From: Ann Machado
To: Helen Donaldson
Date: 7/2/2012 1:49 PM
Subject: Fwd: Re: follow up on Pomeroy Street

Before I can sign off on the Level I Minor Residential Site Plan for zoning, I need two things:

SITE PLAN
LEVEL I-MINOR RESIDENTIAL DEV.
LEVEL II-ROAD IMPROVEMENTS
LAND OF
CHABAD LUBAVITCH OF MAINE INC.
POMEROY STREET
PORTLAND, MAINE

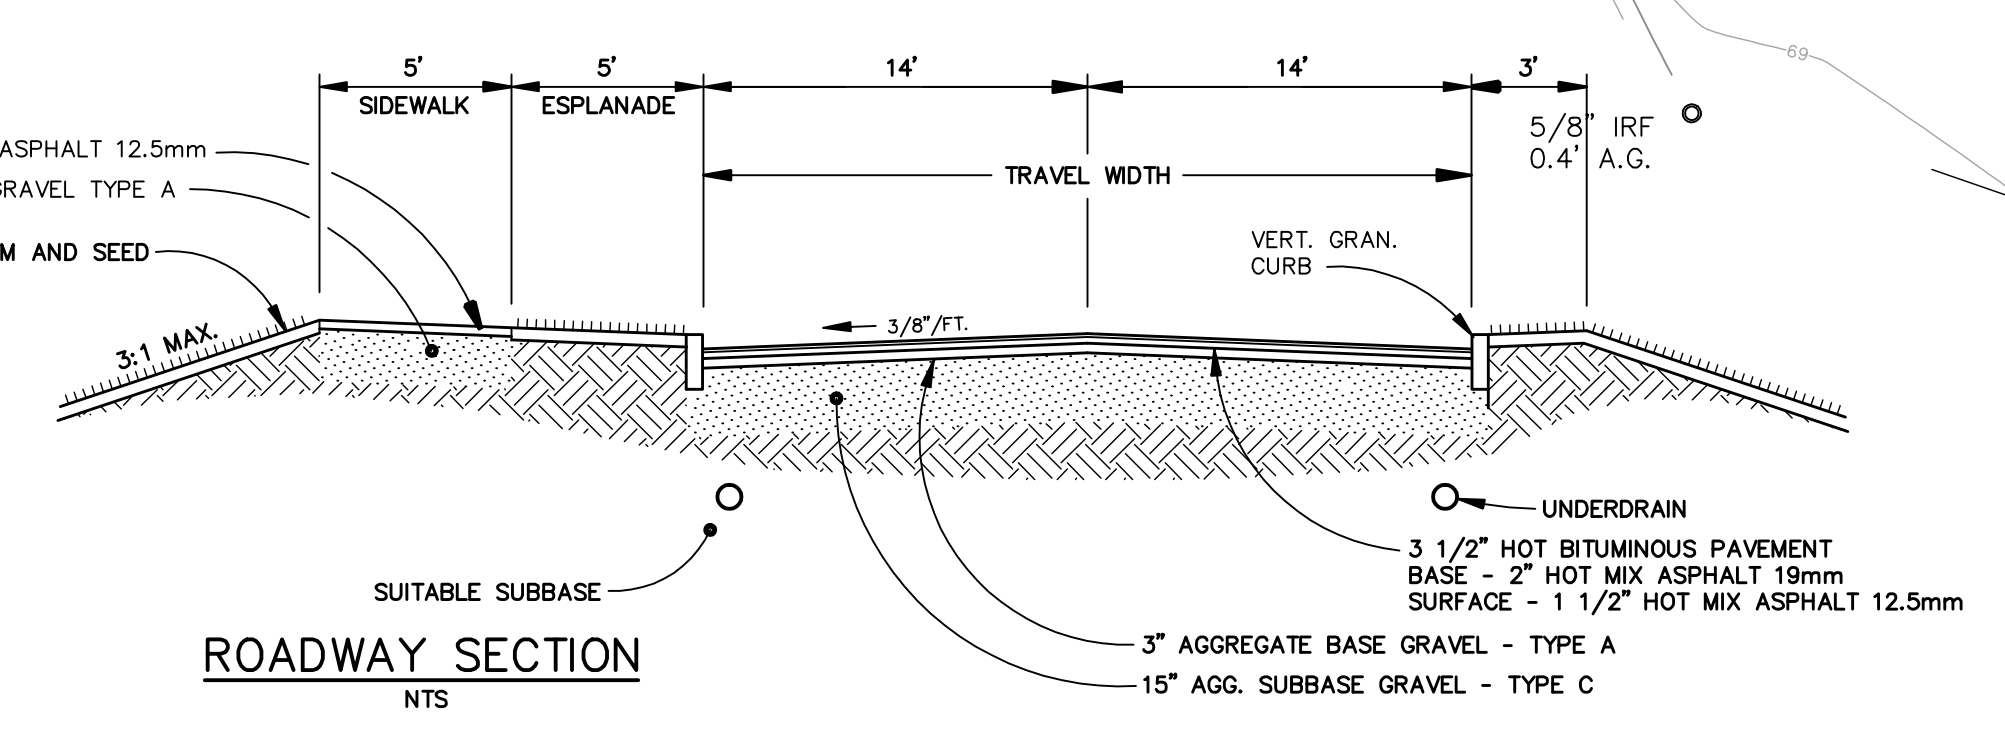
1. I need a written description of the outsale of the land that will be recorded at the registry of deeds.
2. The site plan needs to show the footprints of the three porches that are shown on the building plans.
